70 Anderson St.

Mon, Jul 25, 2016 at 4:20 PM

I am opposed to insisting that the ground floor be raised in the new residential construction at 70 Anderson Street, despite its being a listed R-6 infill standard and despite the recommendation based on that standard by Caitlin Cameron. Here's her citation:

SOUTH WEST ELEVATION VIEW - BUILDING B

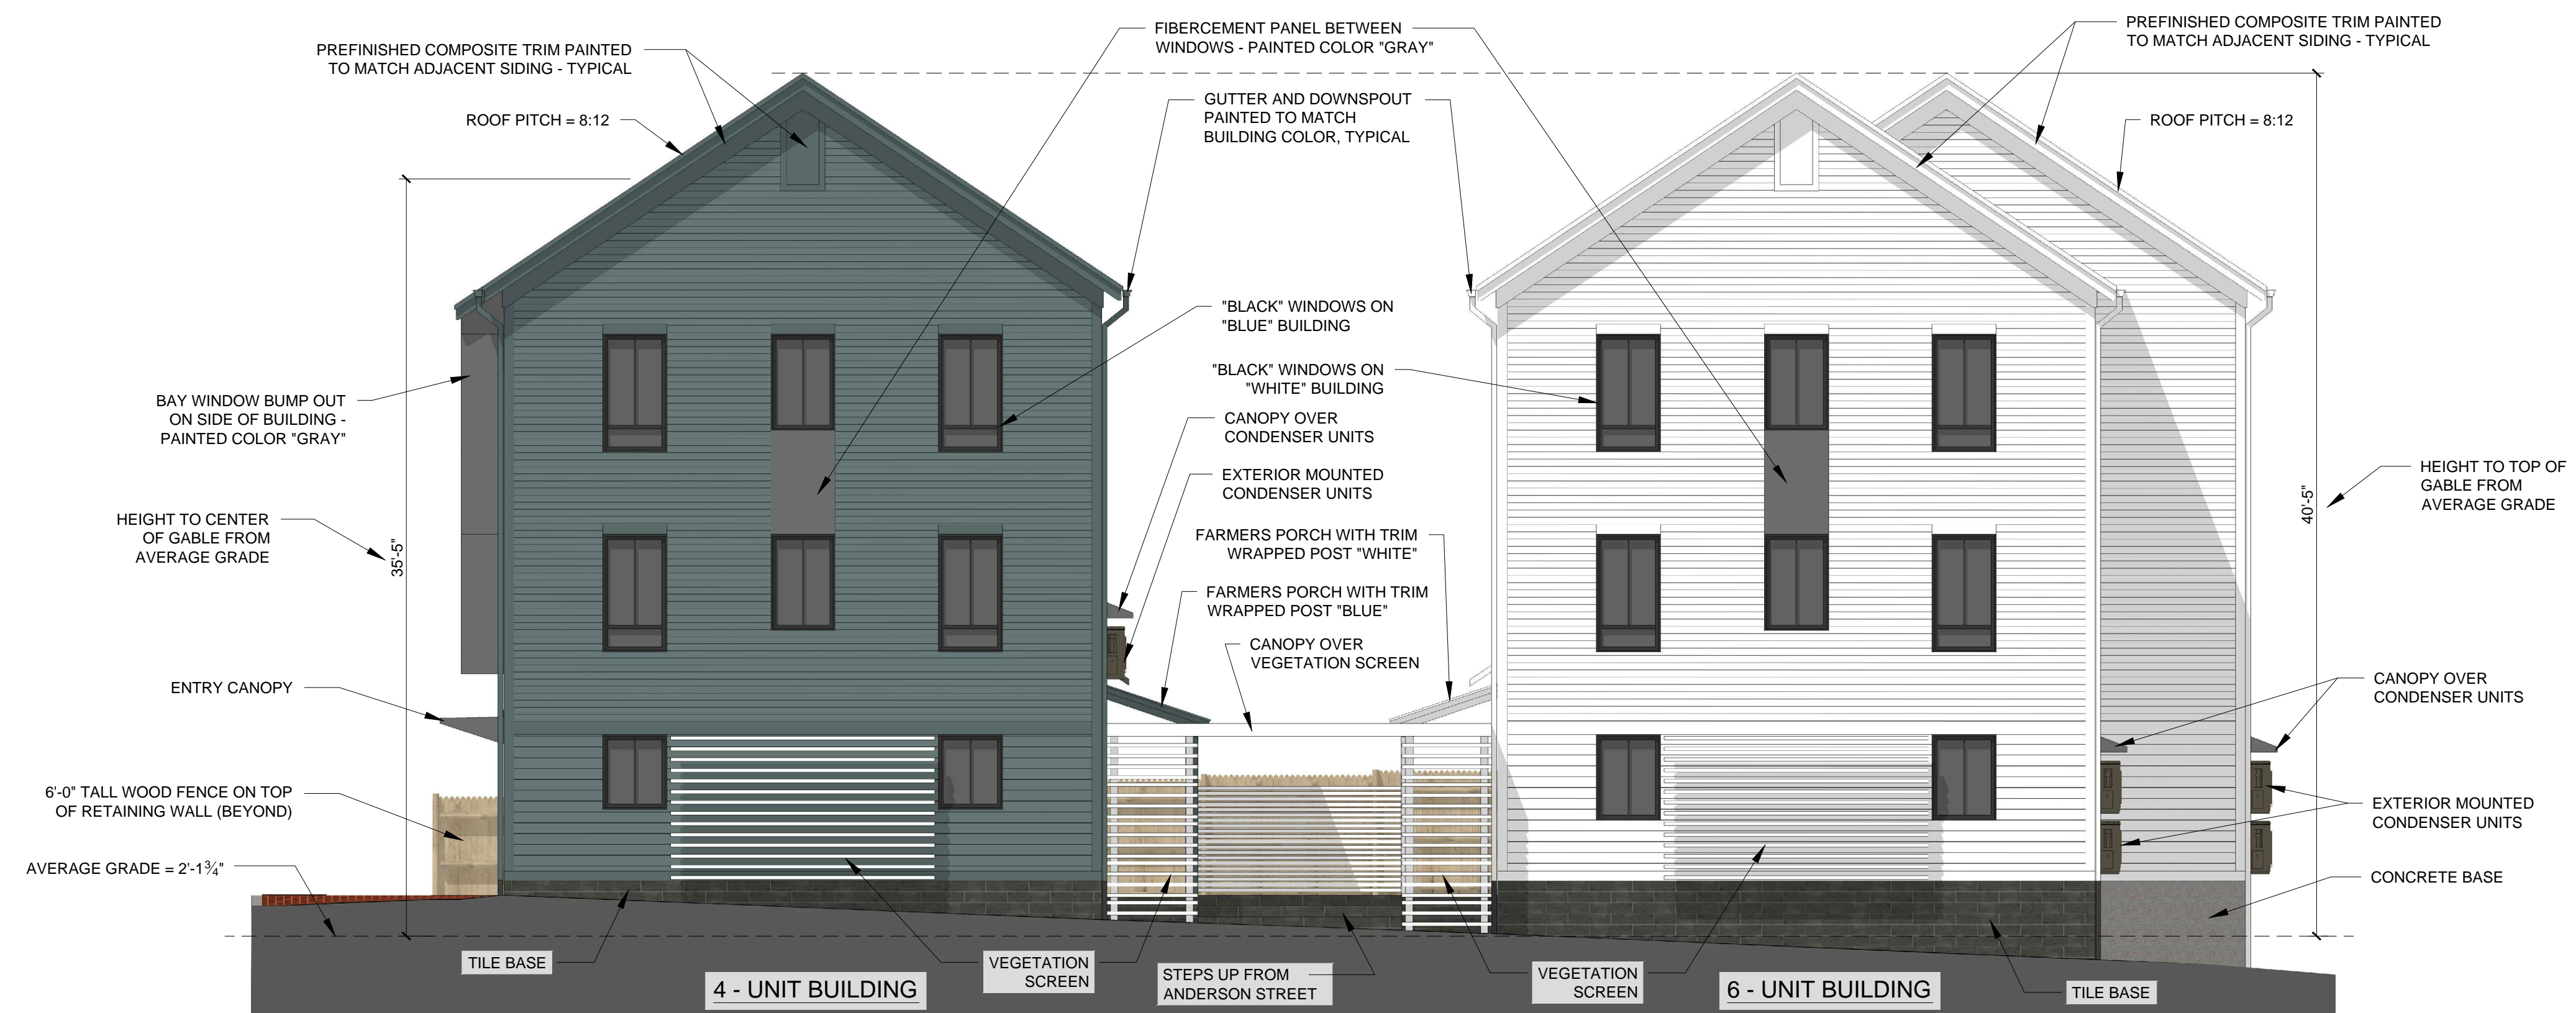
"**Not met.** - A-3 Relationship to the Street: The building placement is consistent with the spacing of the residential fabric – slightly setback from sidewalk to allow for stoops and provide some privacy. **The ground floor is not raised and is not consistent with residential development patterns.**"

First, it was already going to be as tall a building as any other on the street. Now it has been made even taller. (Indeed, here on May Street it's tall skinniness is the primary way it distinguishes itself from other buildings. It was unfortunate that standards were applied to make it conform even less in this most prominent regard.)

Second, an exposed concrete frost wall no more reflects neighboring buildings than clapboard down to the ground. In fact, I would argue that it is less representative of neighboring buildings, since none of them have exposed concrete, and exposed concrete simply accentuates the modernity of the Ollins's building and would presumably do the same on Anderson Street.

A third objection is that the additional costs of shifting from a slab to a frost wall, combined with additional entry steps, grading and filling is not insignificant.

As a result, I would urge the applicant to apply for a waiver of this standard, and I would urge you on the planning staff to recommend its acceptance by the Planning Board.
